Rezoning Transportation Analysis

Petition Number: 2020-167

General Location Identifier: Tax ID 07909935

Date	Description
12-28-20	First Review (EL)
1-21-21	Second Review (EL)

SCHEMATIC SITE PLAN

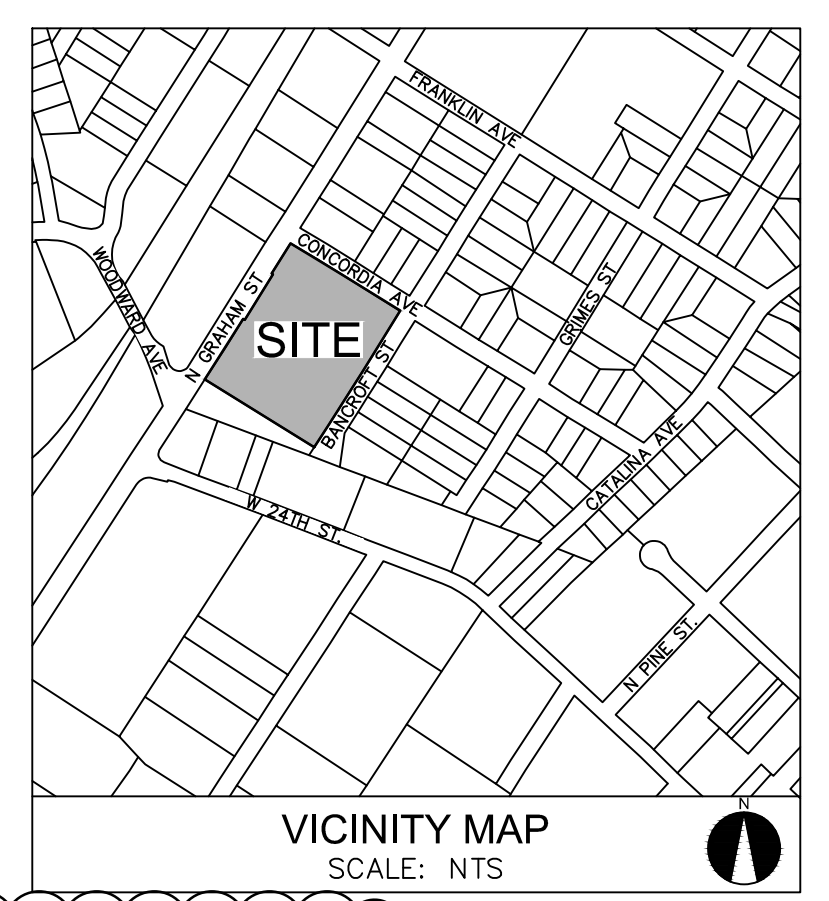
1. **Outstanding (site plan dated 01/11/21) Curblines:** The proposed zoning district has a setback measured from back of the existing or proposed future curblines.
 - a. **North Graham Street:** Location of curb and gutter needs to be moved 32.5-feet from road center to proposed back-of-curb, to accommodate the future 4-lane Avenue road cross section with buffered/separated bike lanes.
 - b. ~~**Concordia Avenue:** Location of curb and gutter needs to be installed at the existing edge of pavement.~~
 - c. **Bancroft Street:** Location of curb and gutter needs to be installed along the property frontage, according to CLDSM standard detail number *U-03A – Local Residential Wide Street Typical Section*, from road centerline.

Label and dimension the curb and gutter from the centerline for each road on the site plan.

- ~~9. In accordance with the Charlotte WALKS Plan, revise site plan and conditional note(s) to provide sidewalk for pedestrian circulation to proposed buildings E, F, J, and I.~~
- 10. Outstanding (site plan dated 01/11/21)** A site plan note specifying that all transportation improvements will be approved and constructed before the site's first building certificate of occupancy is issued is needed. The petitioner may phase transportation improvements if said improvements and phasing are explicitly described in site plan notes.
- 11. New Comment (site plan dated 01/11/21)** Conditional note (Section F.2.) needs to be revised to clarify that an 8-foot planting strip and 8-foot sidewalk will be constructed along North Graham Street. The site plan needs to be updated to show the curb line being relocated for a buffered bike lane, rather than a 12-foot shared-use path.

2. A MINIMUM 8 FOOT WIDE PLANTING STRIP AND A MINIMUM 12 FOOT WIDE MULTI-USE PATH SHALL BE INSTALLED ALONG THE SITE'S FRONTAGE ON NORTH GRAHAM STREET.<

- 12. New Comment (site plan dated 01/11/21)** Conditional note (Section D.4.) needs to be updated to reflect that the streetscape improvements listed within (Sections F.1. and F.2.) will also be completed prior to first certificate of occupancy, in reference to outstanding issue 10.
